From: Molly Bland [molly.bland@fish4mail.co.uk]
Sent: 31 January 2008 10:24
To: Planning.Responses
Subject: RE: Planning Consultation on: FN/78/07/L

Findon Parish Council objects to this application.

APPLICATION NO:	FN/78/07/L
Registered:	24-DEC-07
Site Address:	Averys House High Street Findon
Grid Reference:	512105 - 108479
Category:	Listed Bldg Con

Description of Works: Application for Listed Building Consent for works to window and other internal alterations.

EAST ELEVATION @ 1:50

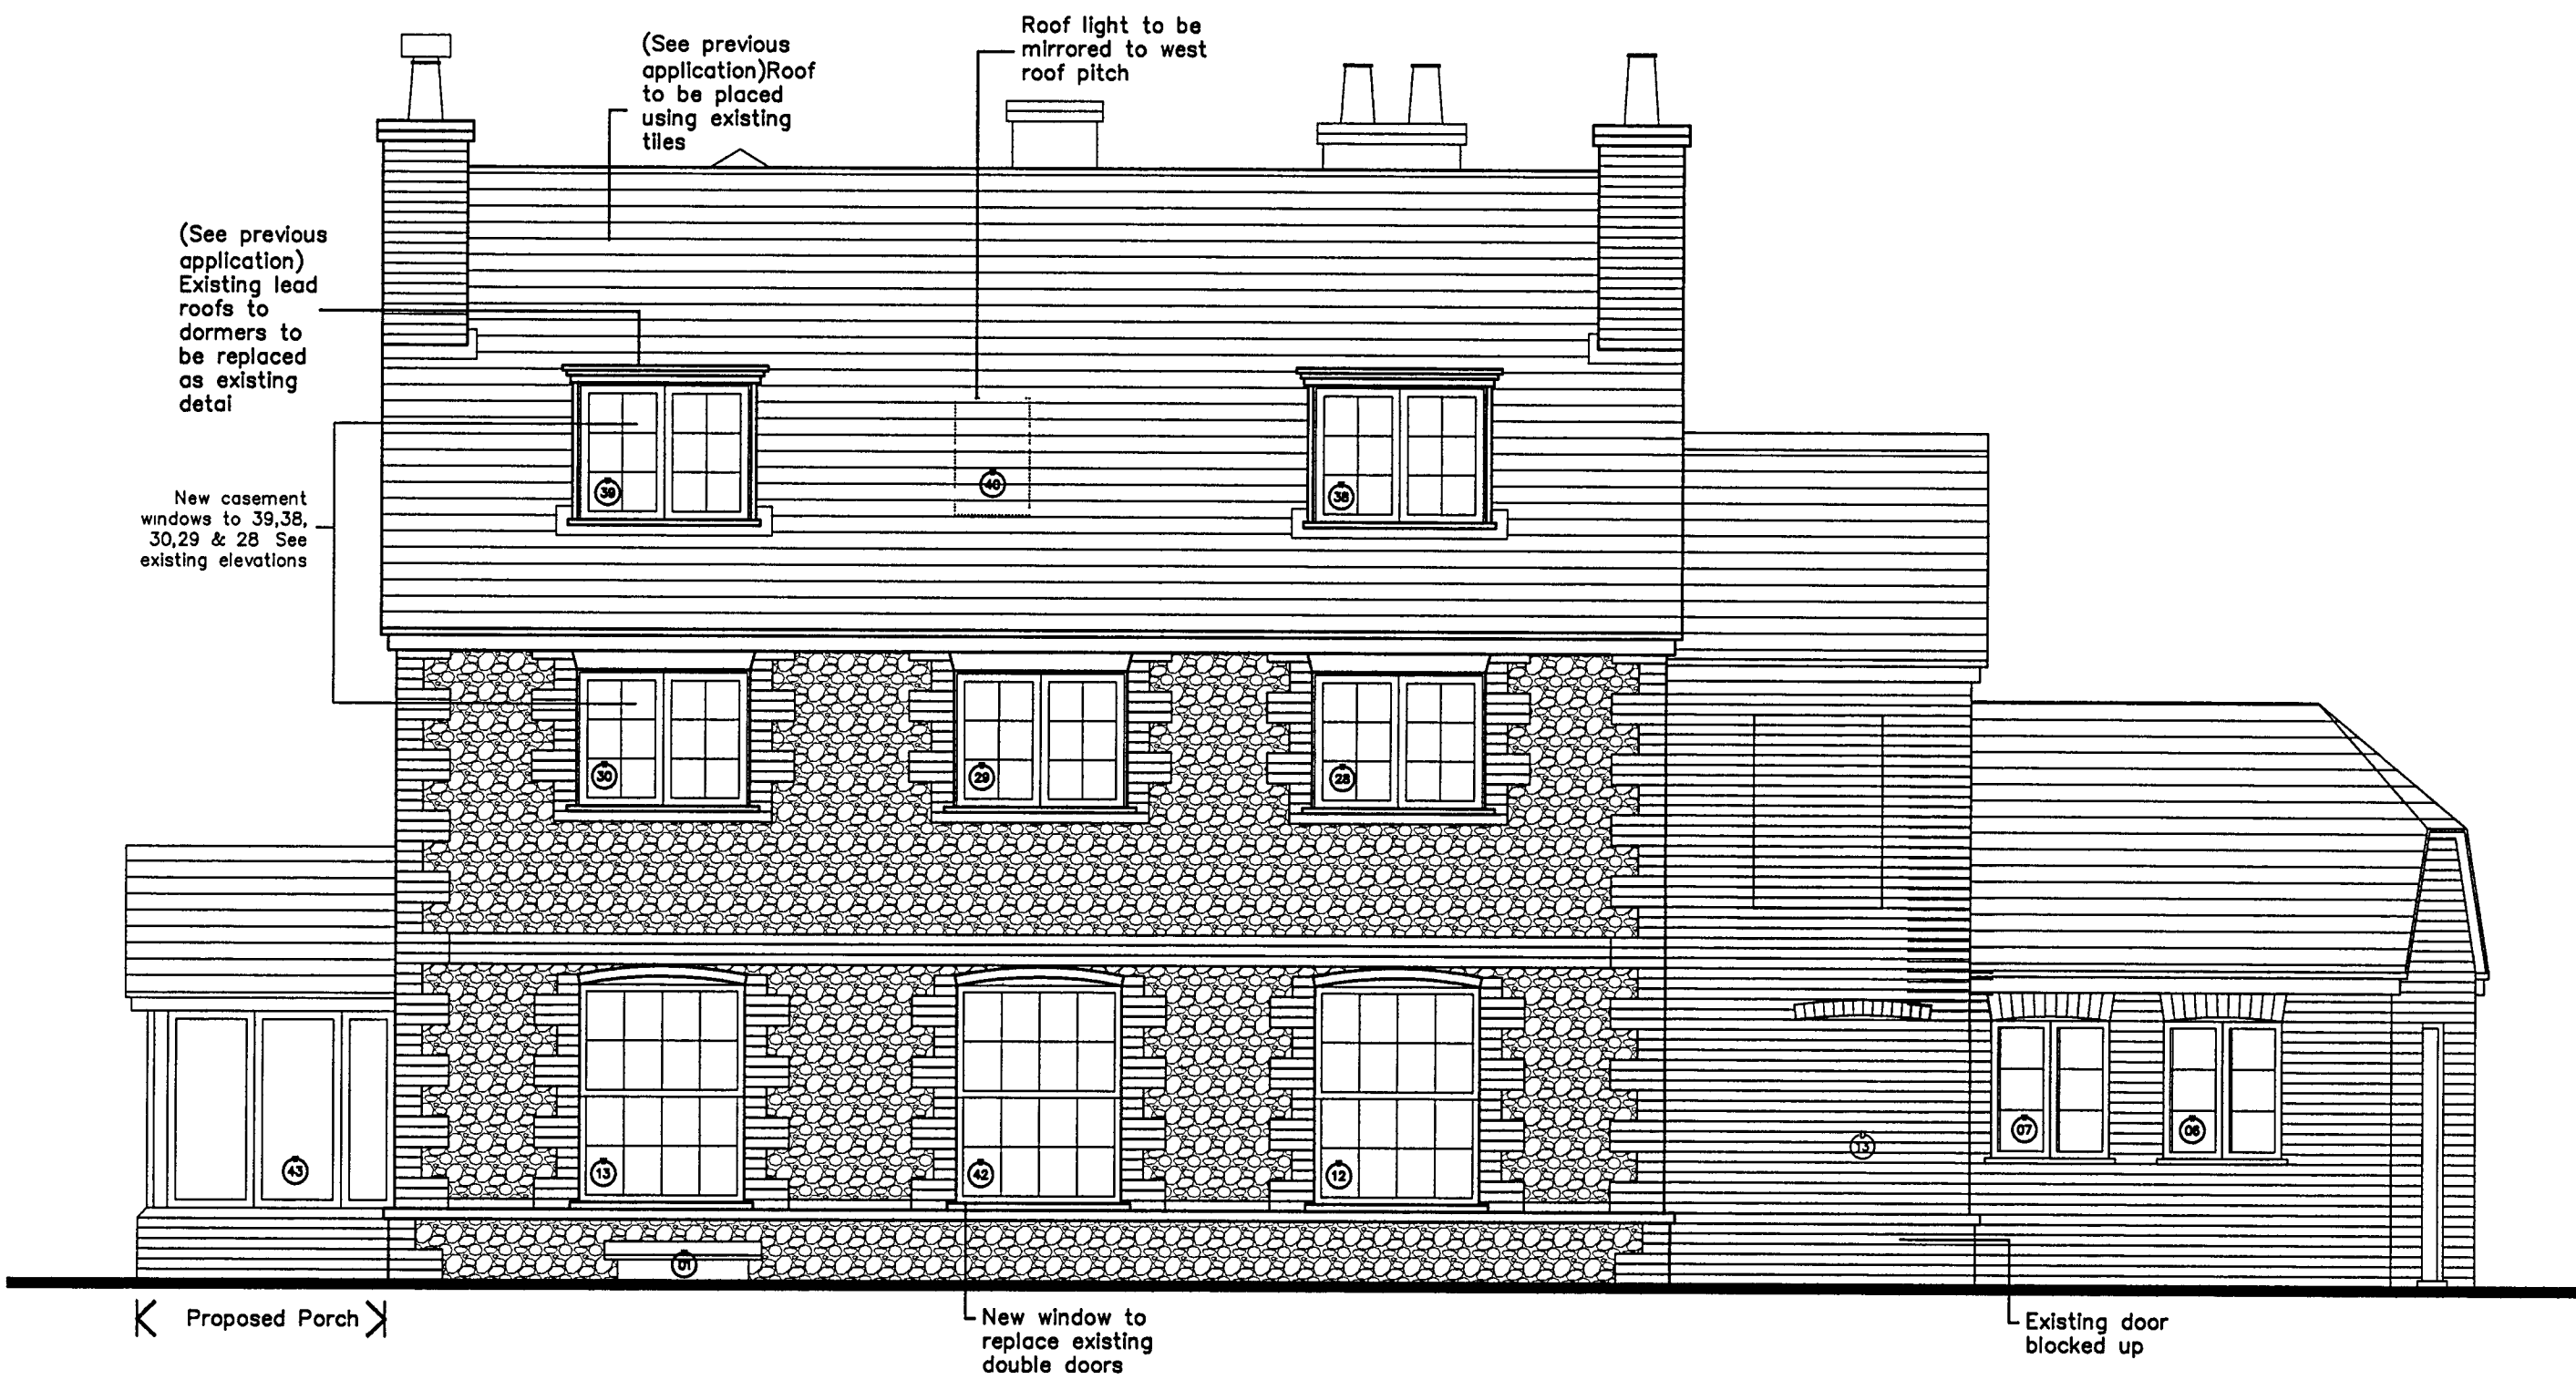
The building is Grade 2 Listed, the proposals for altering the windows, e.g. those on the East elevation which are traditional horizontal Sussex sashes, would adversely affect the existing Listed character of the external elevations of the house.
